## Beacon Fen Energy Park – Development Consent Order

Application reference: EN010151

Document: Deadline 6 – Response to Low Carbon’s Technical Note prepared in response to CAH1

### Executive summary (LCJM D6 response to Applicant’s Appendix 1 / CAH1 Action No. 2)

**Ex D6.24** Map showing - beyond “Indicative LCJM Amended Alternative Access Option 2” – the purple line on Little Hale Drive - **why would the applicant not use the black dashed line [red arrows] to avoid all longitudinal interaction with the Great Hale Eau LWS?**

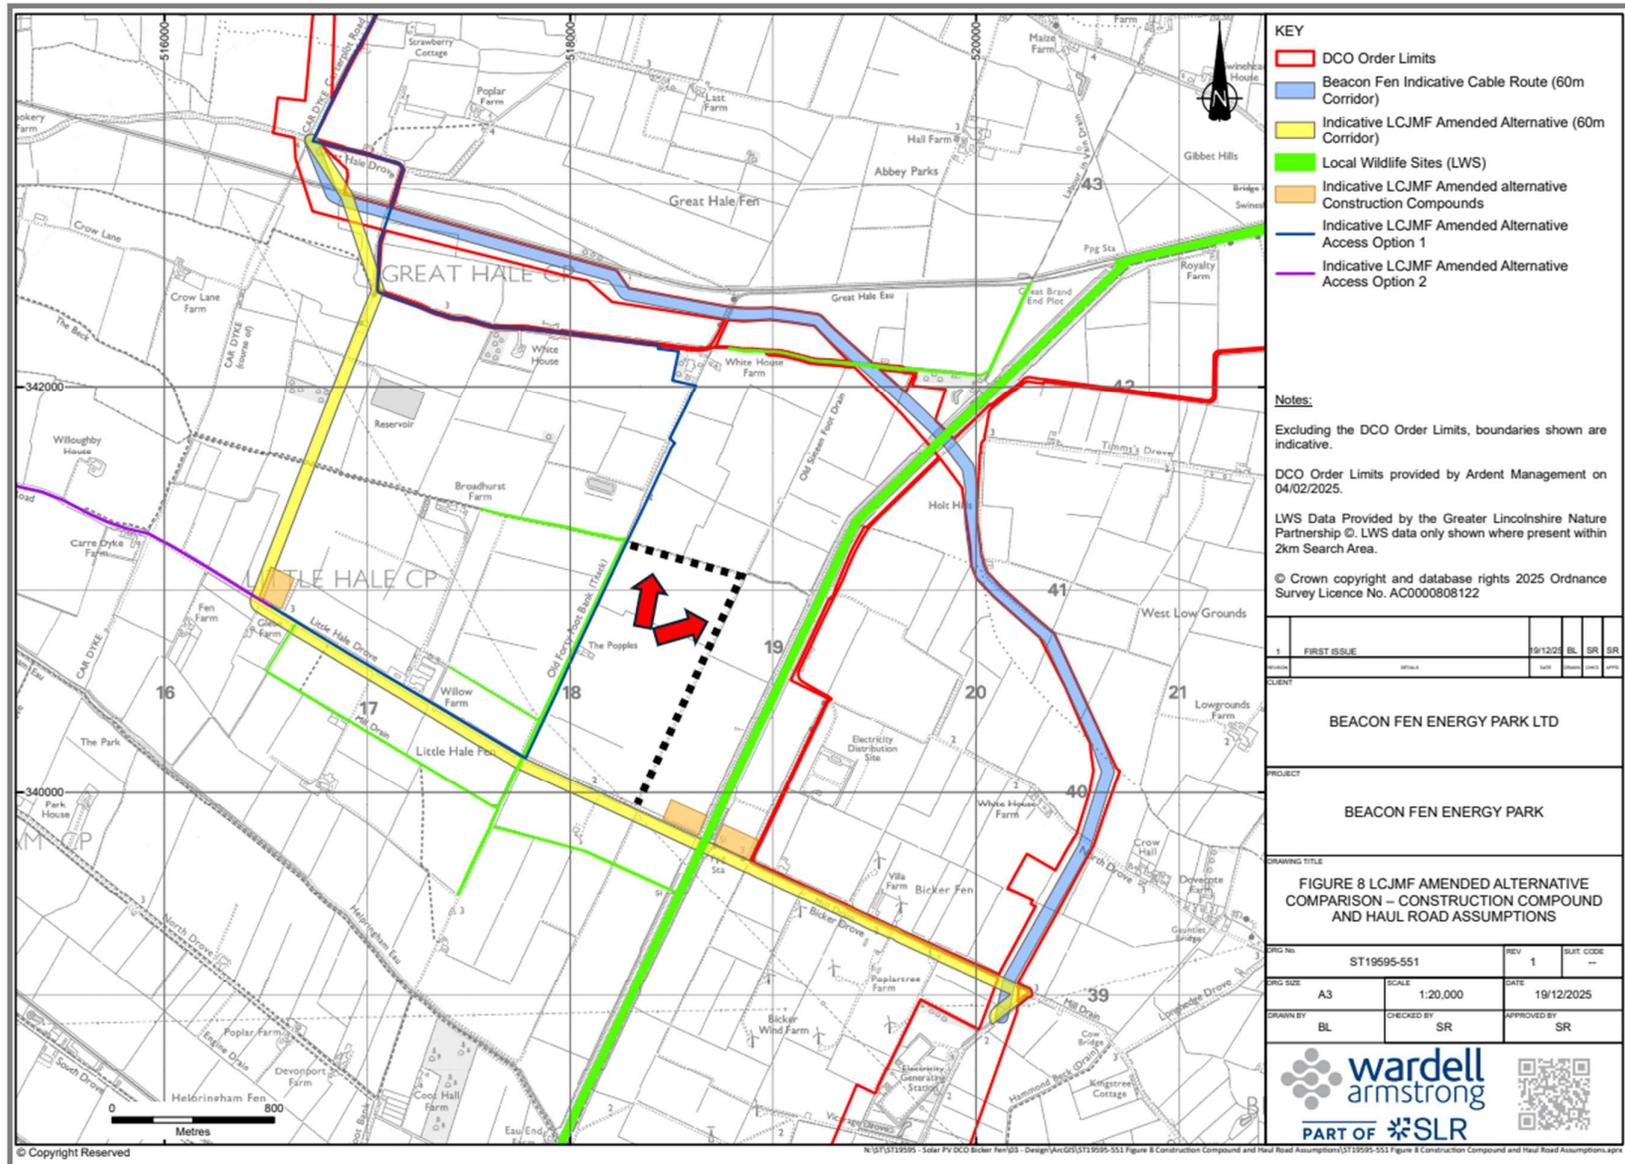
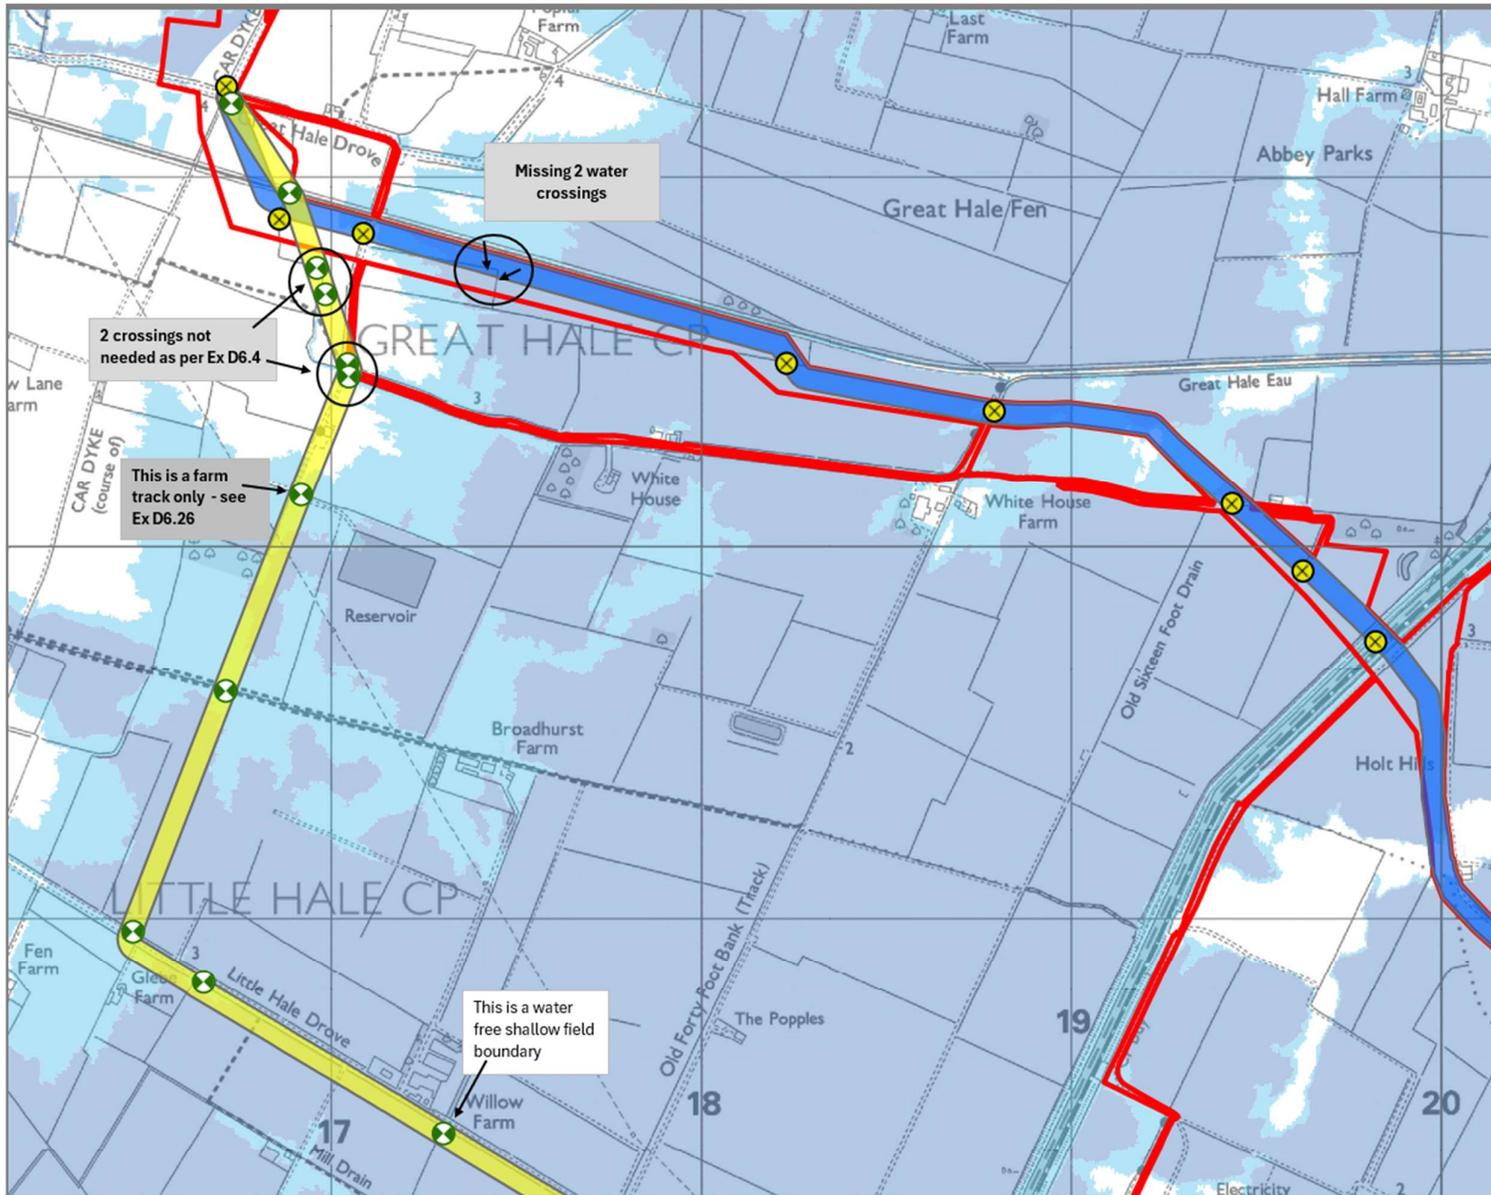
The Applicant’s Table 1 / Appendix 1 data is then analysed in the row-by-row critique in Section 6, including errors in (i) residential “dwelling” counts (farm buildings treated as dwellings and key Beacon Fen dwellings excluded by corridor-only screening), (ii) watercourse crossings, (iii) highway crossings, and (iv) the deliberate choice to longitudinally occupy LWS 4490 (Old Forty Foot) where a perpendicular farm track can be used to avoid this interaction altogether (Ex D6.24).
